Please see attached email from our structural engineer regarding the submitted plans for the "Jonah Williams Residence" at 401 D L Phillips Ln Broadway, NC. This email is stating the weight bearing on the footings. I hope this gives the correct insight to have our building plans approved. If you have any further questions or concerns please contact me at this email or at (910) 759-1754.

Subject: RE: Foundation Evaluation

Sheet Title
FOUNDATION PLAN

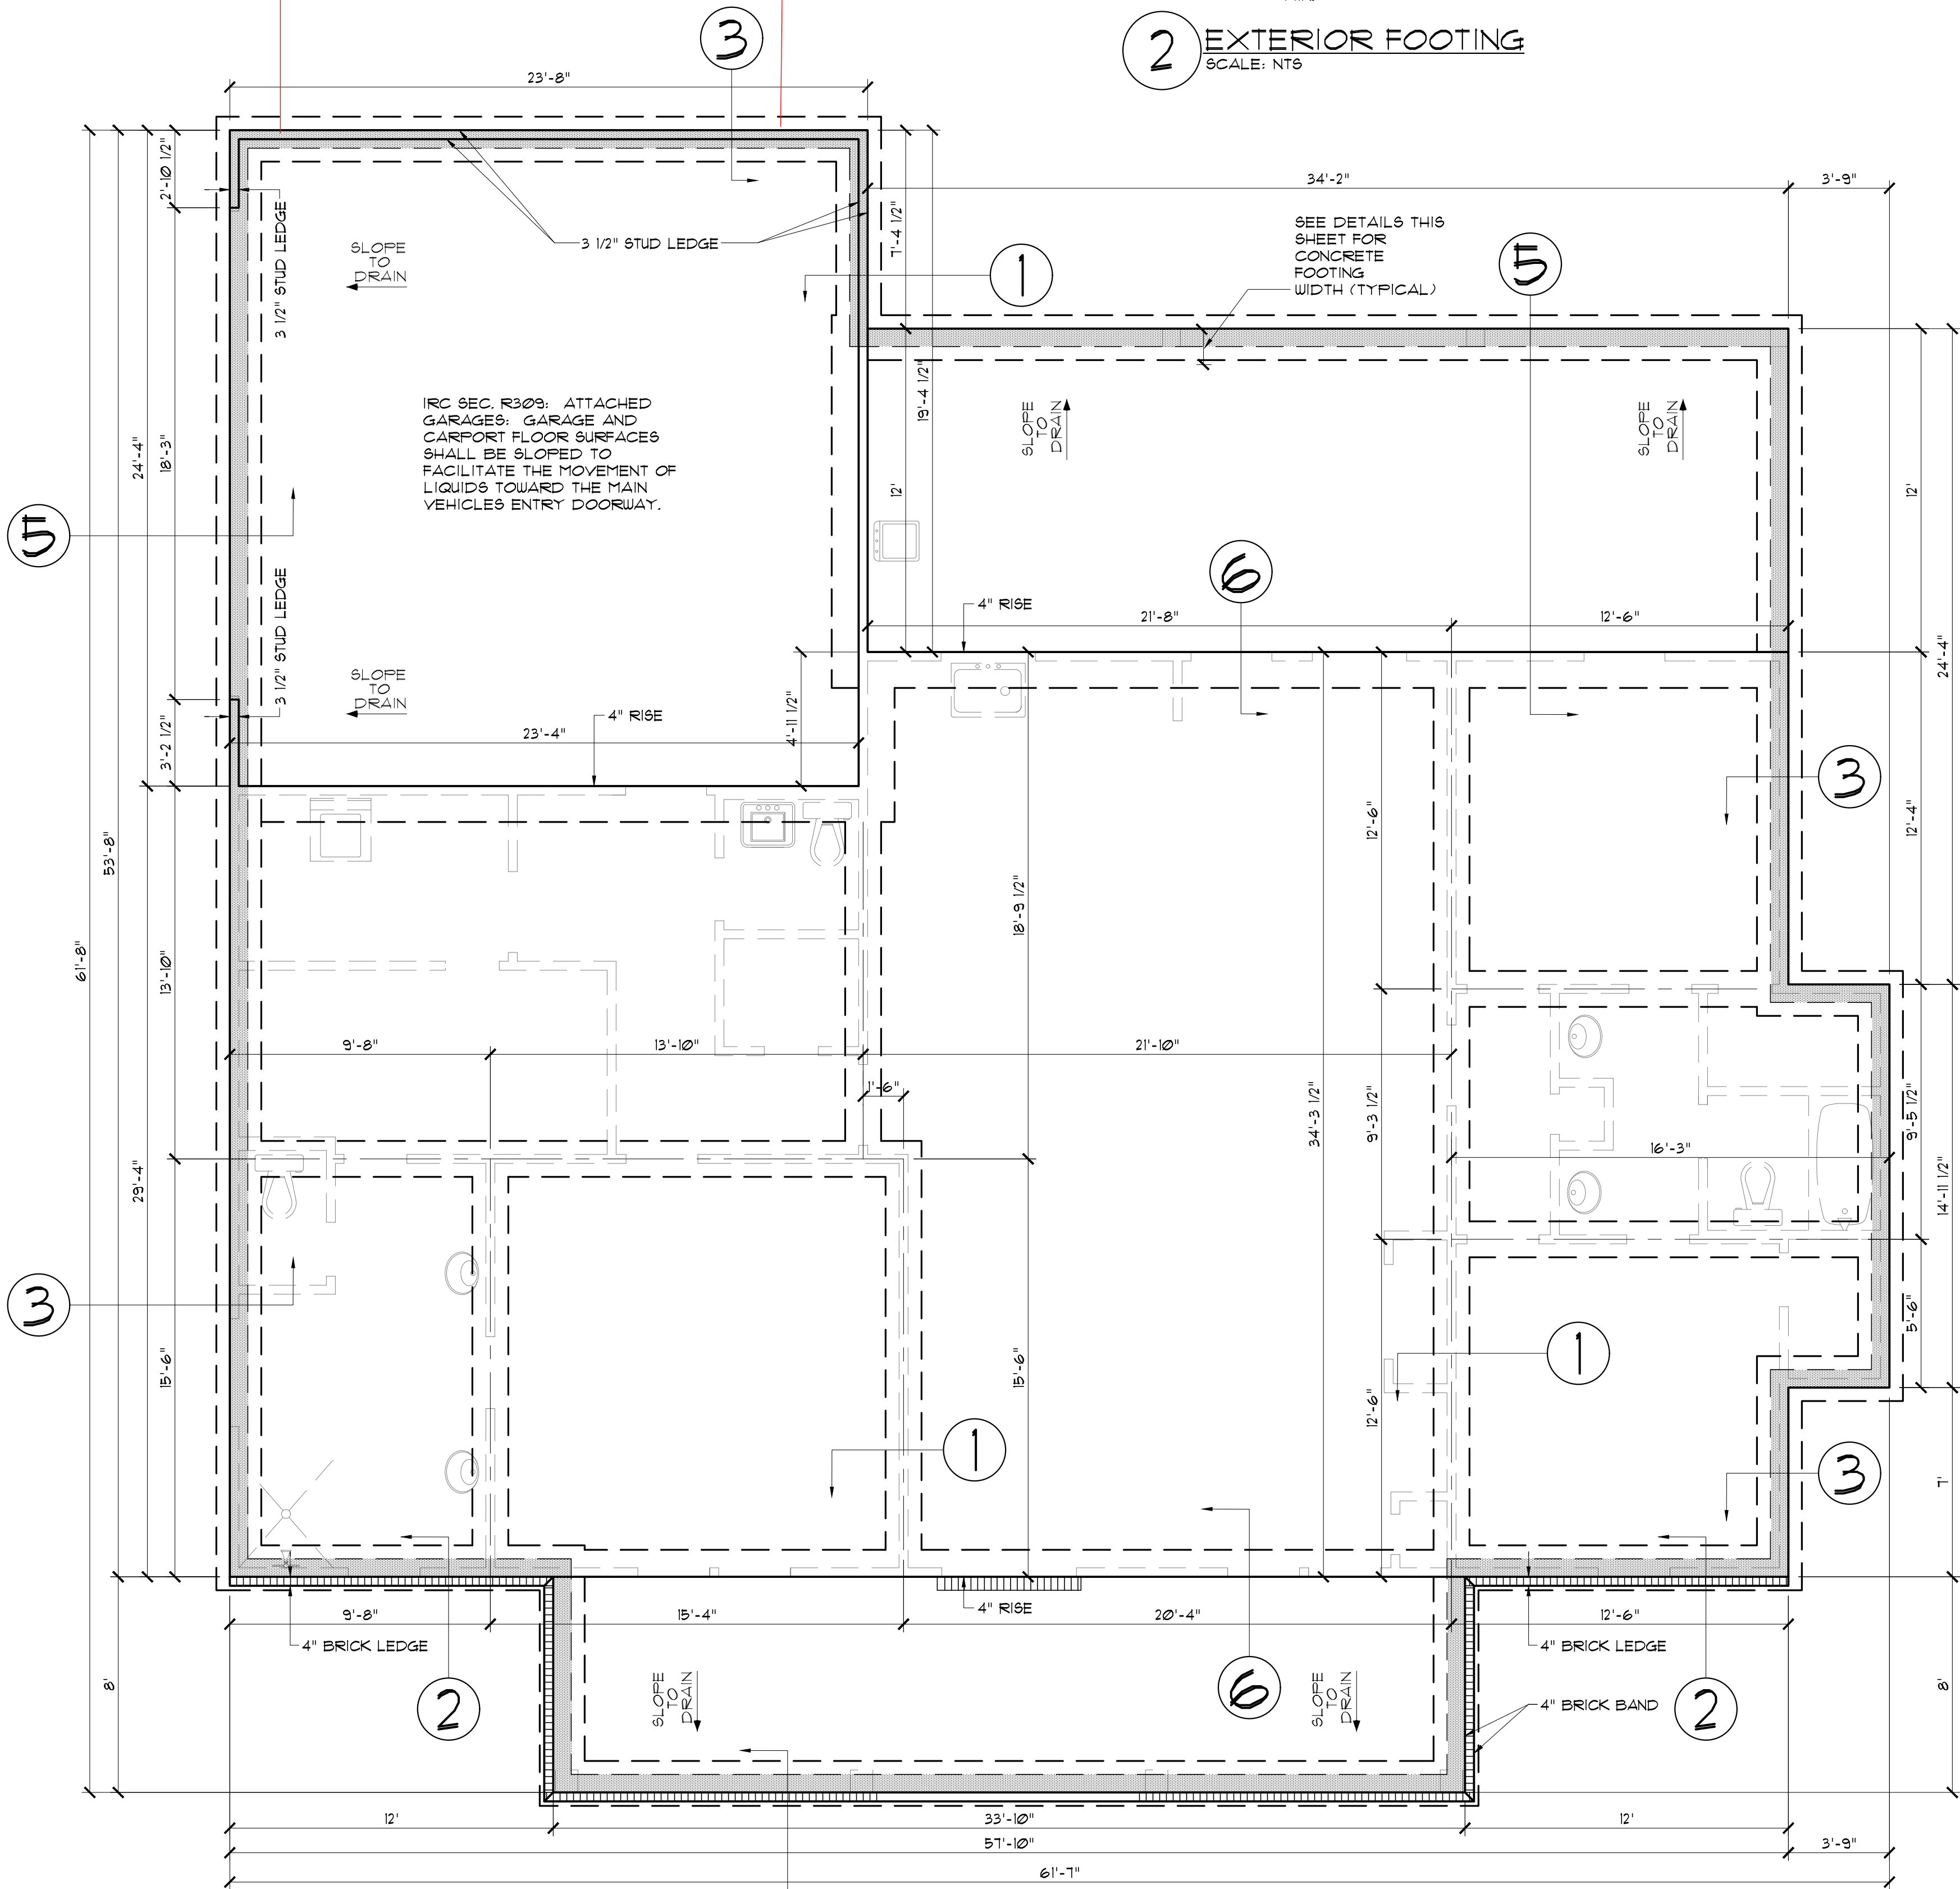
Sorry, I've been out of town, just getting back. Based on the +/-8,100 lbs reaction of GDH beam, the 2' wide x 1' deep continuous footing w/ (2) #5's reinforcing should be adequate at the opening, assuming the footing is bearing on soils that have a 2,000 psf soil bearing capacity. Structurally, the bearing footprint for the beam support end bearing point load is approximately 2' (width of the footing) x 3' (length that develops load transfer). Therefore, we should have roughly 12,000 lbs bearing capacity at this location of the footer versus a 8,100 lb point load.
